WEST SUSSEX COUNTY COUNCIL CONSULTATION

TO:	Arun District Council - FAO: Anita Gardner
FROM:	WSCC - Highways Authority
DATE:	1 March 2021
LOCATION:	46a & 47 Pier Road and Land North of Clifton Road Littlehampton BN17 5LW
SUBJECT:	LU/3/21/DOC Approval of details reserved by condition imposed under ref LU/287/17/PL relating to Condition Nos 6 - Construction Management Plan and 13 - hard & soft landscaping. More info received from Anita Gardner's email.
RECOMMENDATION:	Advice / No Objection

West Sussex County Council, in its capacity as the Local Highway Authority (LHA), have been re-consulted on discharge of condition 6 (Construction Management Plan) of approval LU/287/17 (office use plus 8 x dwellings).

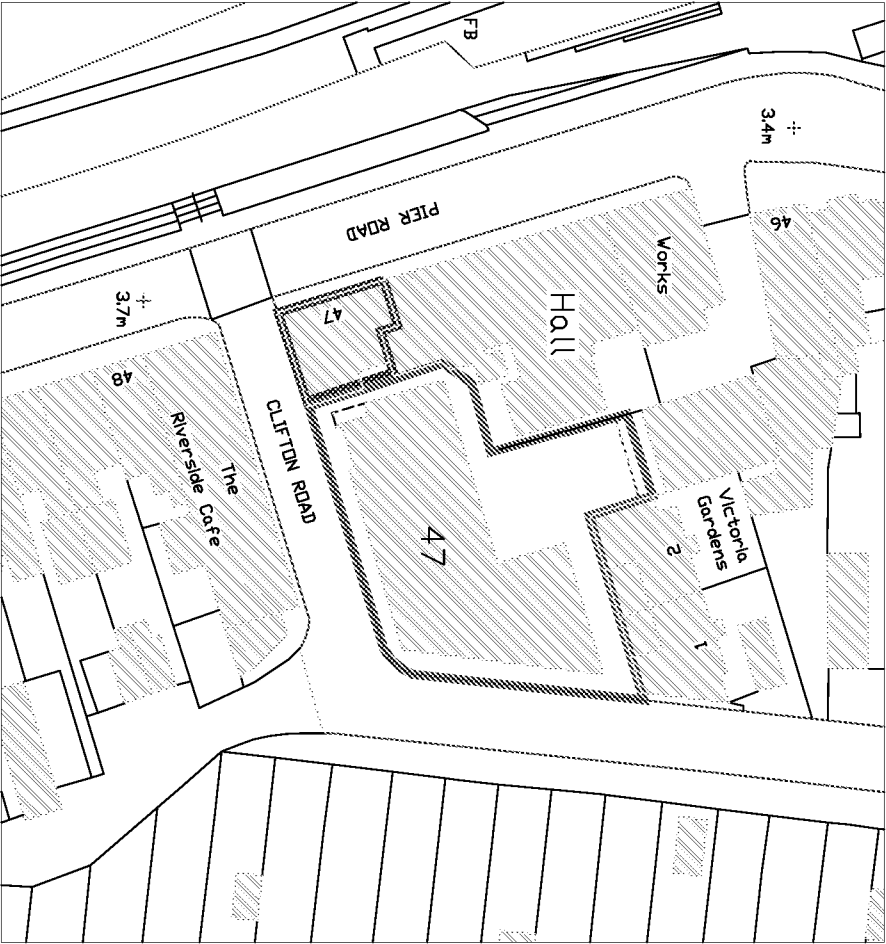
It is also unclear from WSCC highway boundary mapping whether a small slither of public highway adjacent site boundary is to be enclosed by the hoarding. The LHA does not envision any highway safety concern with the proposed arrangements, however would advise that the applicant contact the Area Highway Manager for Arun to confirm that no hoarding licence is required and to also confirm no articulated vehicles/other deliveries from Pier Road which may require traffic management.

APPENDIX B – CONTRACTOR SITE PARKING / STORAGE AREA (DRG 003)

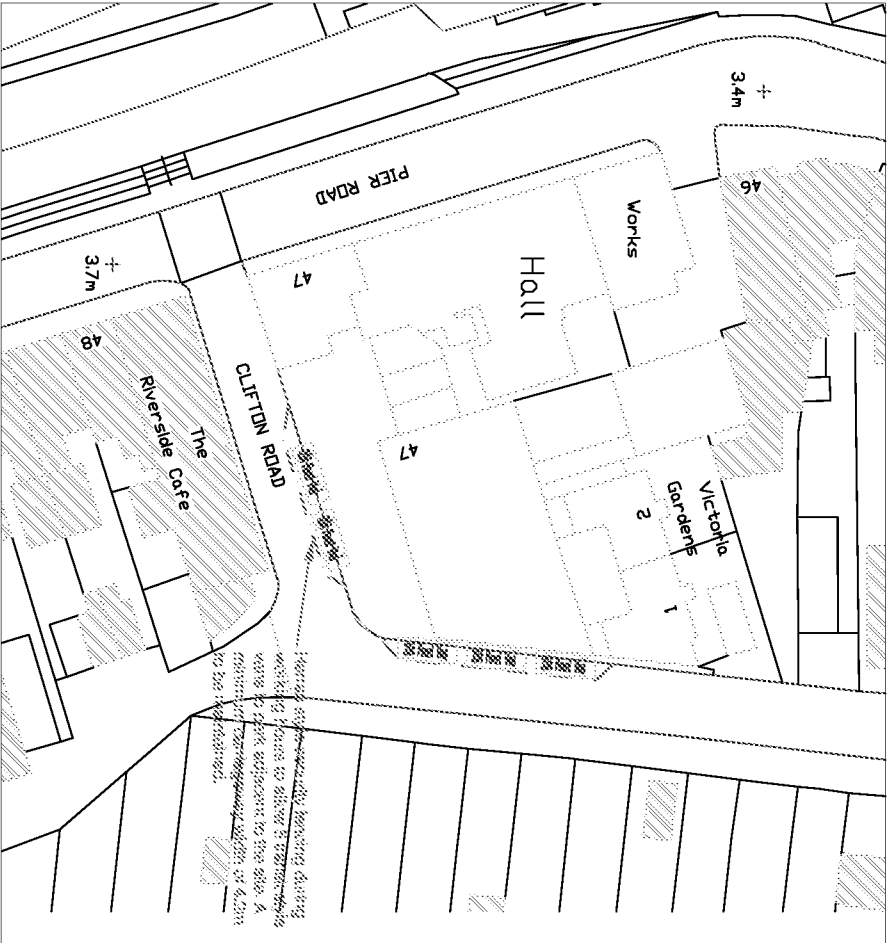
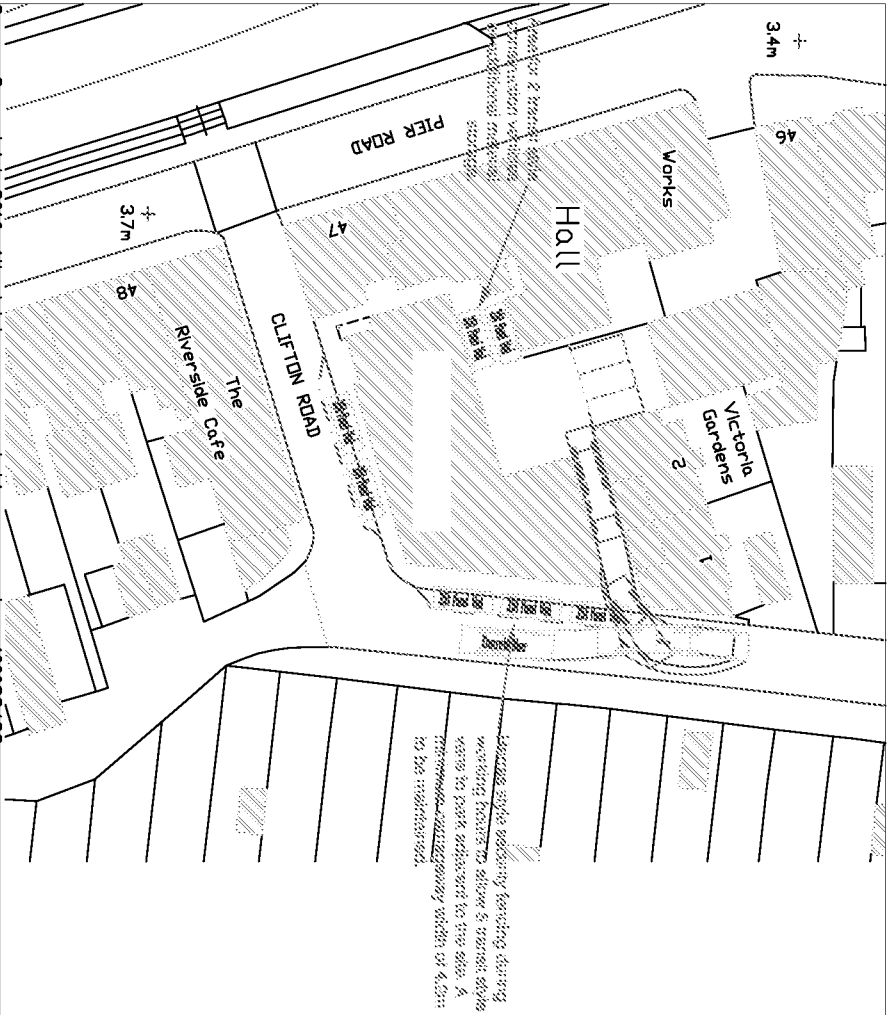
In comments dated 10 February the LHA requested further information in regard to the contractor parking which was shown along Clifton Road and clarification on number of articulated lorry movements.

An amended plan has been provided that shows parking within the site and not on the public highway. It is advised that the CMP is amended or superseded as the plans in appendix still show parking on Clifton Road.
